**Section 96A of the Town & Country Planning Act 1990 (as amended)
Town and Country Planning (Development Management Procedure) (England) Order 2015 (as amended) - Article 10**

**Non material amendment following BN/19/18/PL to increase depth of house.
The Cottage Piggeries, Church Lane, Barnham,**

Proposed Ground Floor Plan

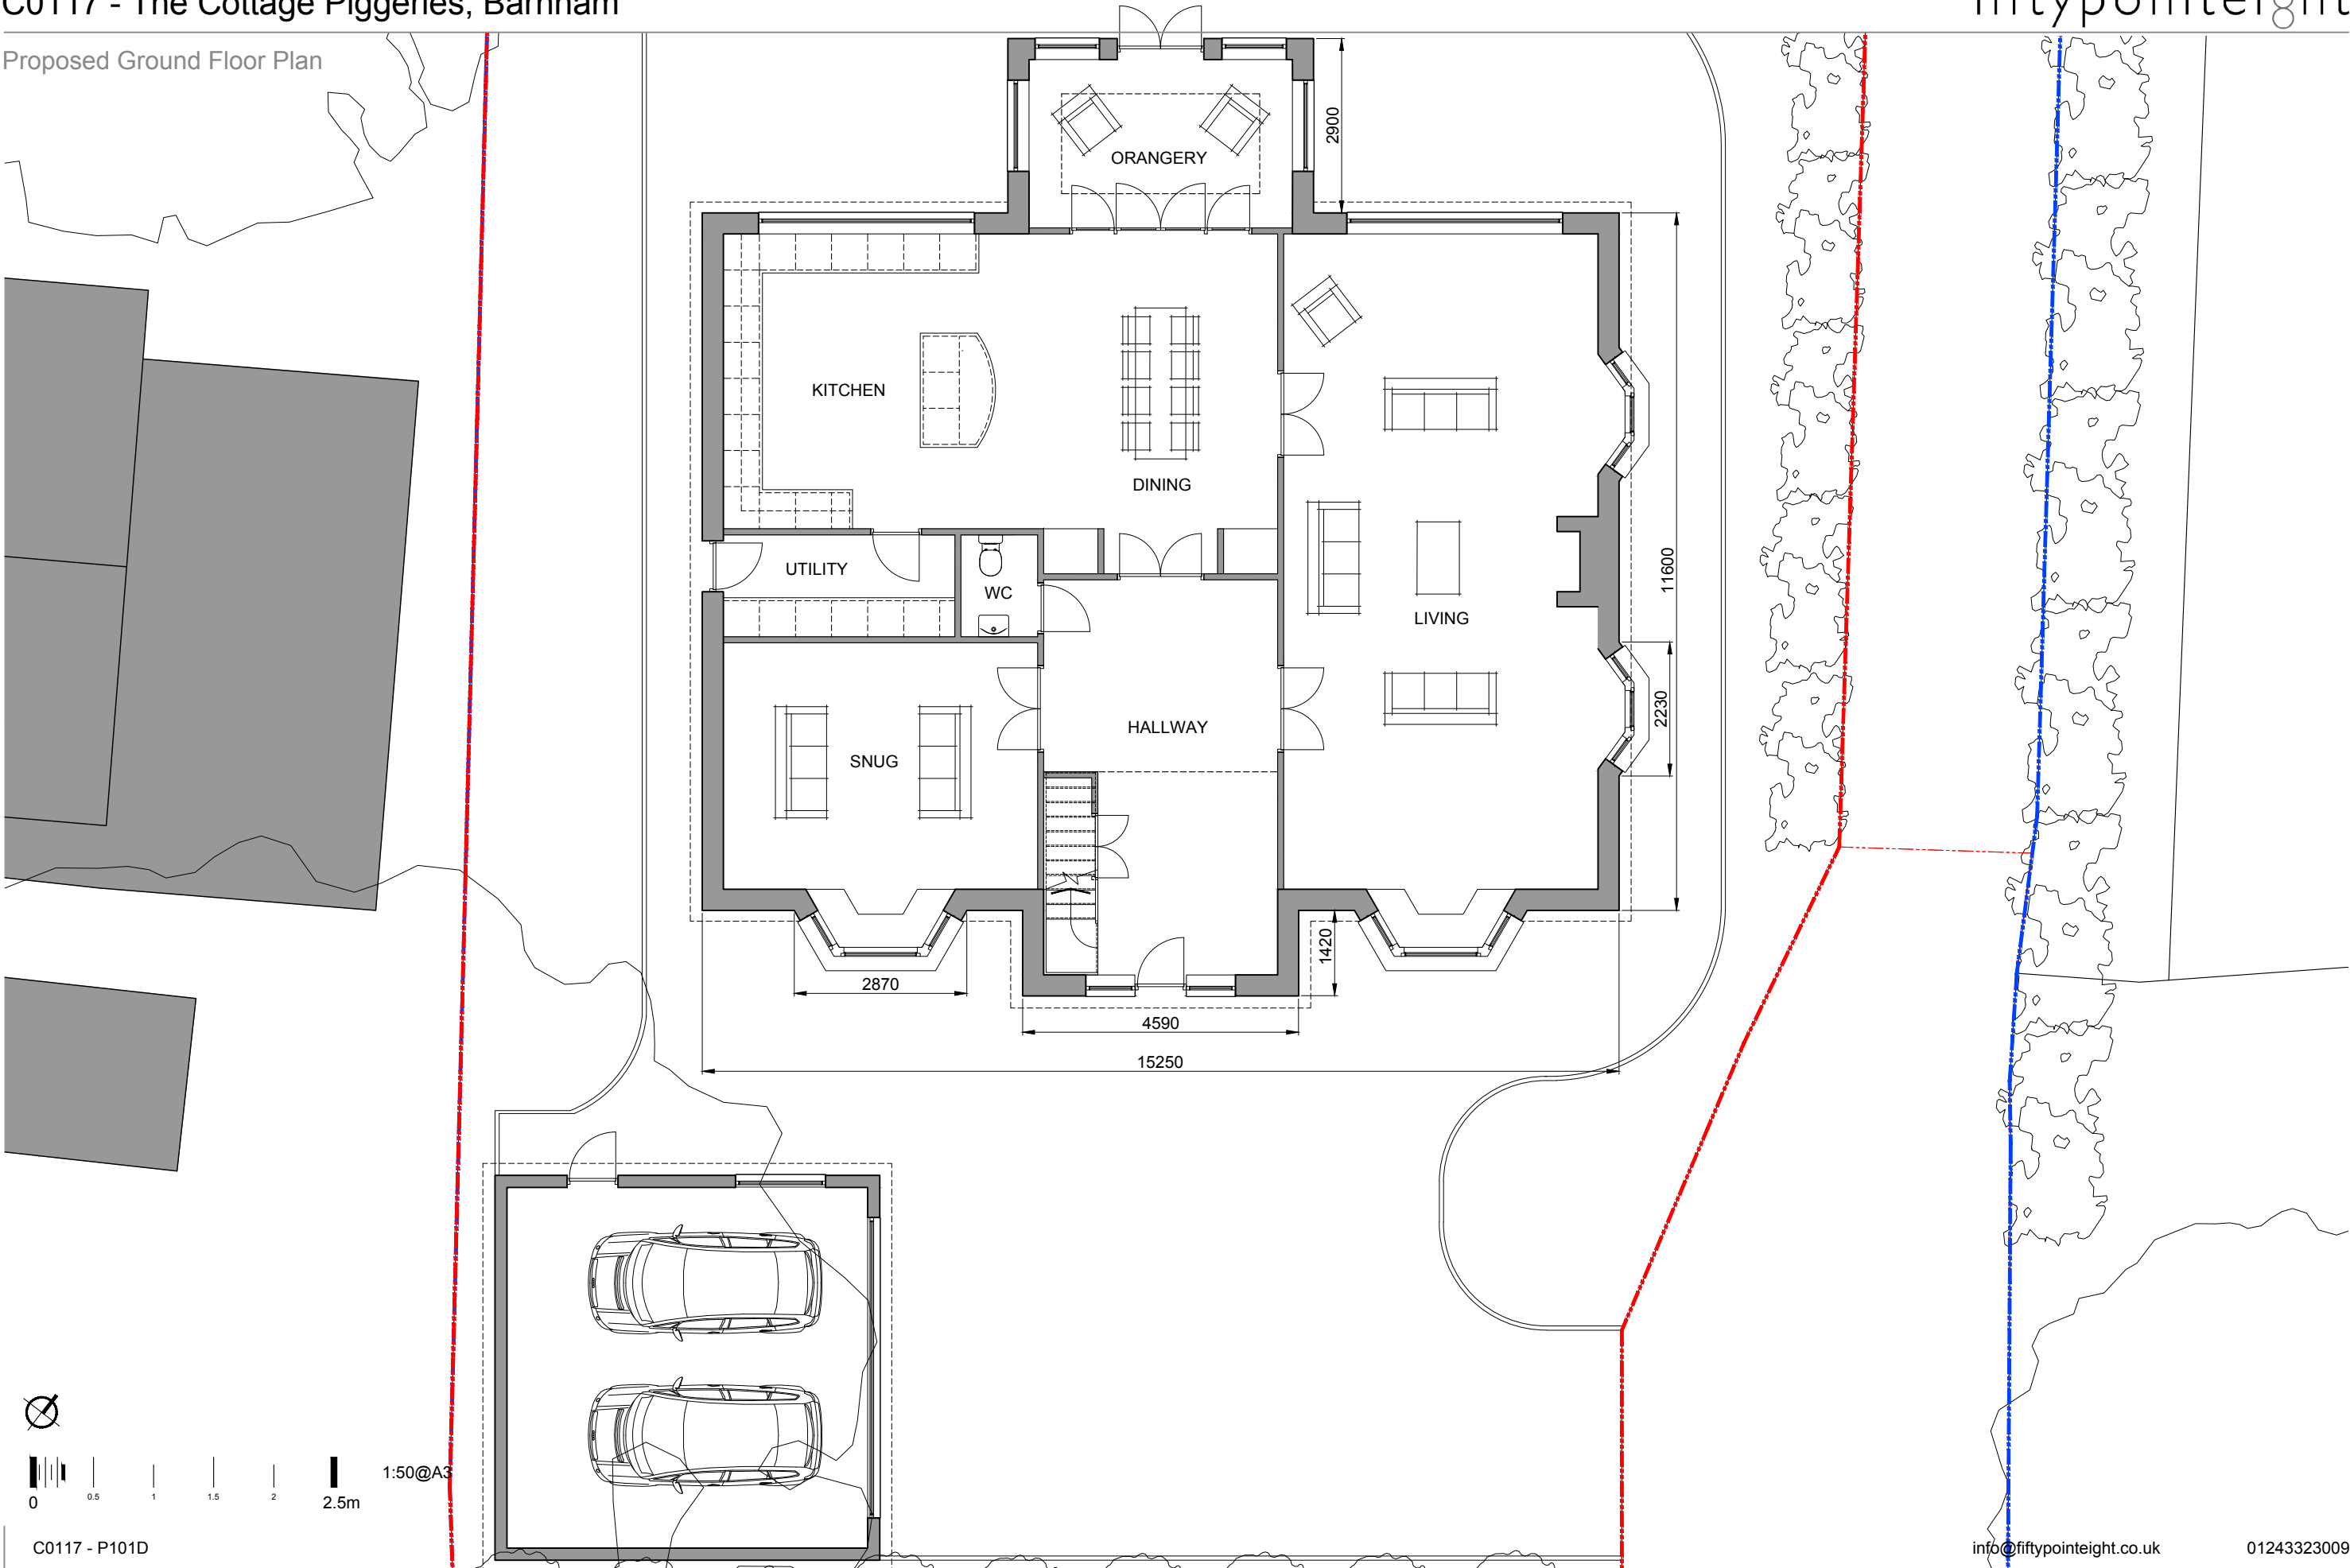
- (a) Increase the depth of the proposed house from 10.7m to 11.6m; and
- (b) Incorporate new material detailing to the corners of the proposed elevations.

The reasons that these proposals have been accepted as Non-Material Amendments is because the changes do not amend the intensity of the original planning, do not result in a change to the description of the application or conflict with any conditions of the permission, do not amend the red edged site area, do not breach planning policy, do not introduce new windows, do not materially alter the external appearance of the building and do not result in an increase in width or depth of more than 1m.

Please also note that we have not approved any particular material in respect of the new corner detailing to the elevations and therefore, you will need to reapply to discharge condition 04 of BR/19/18/PL in
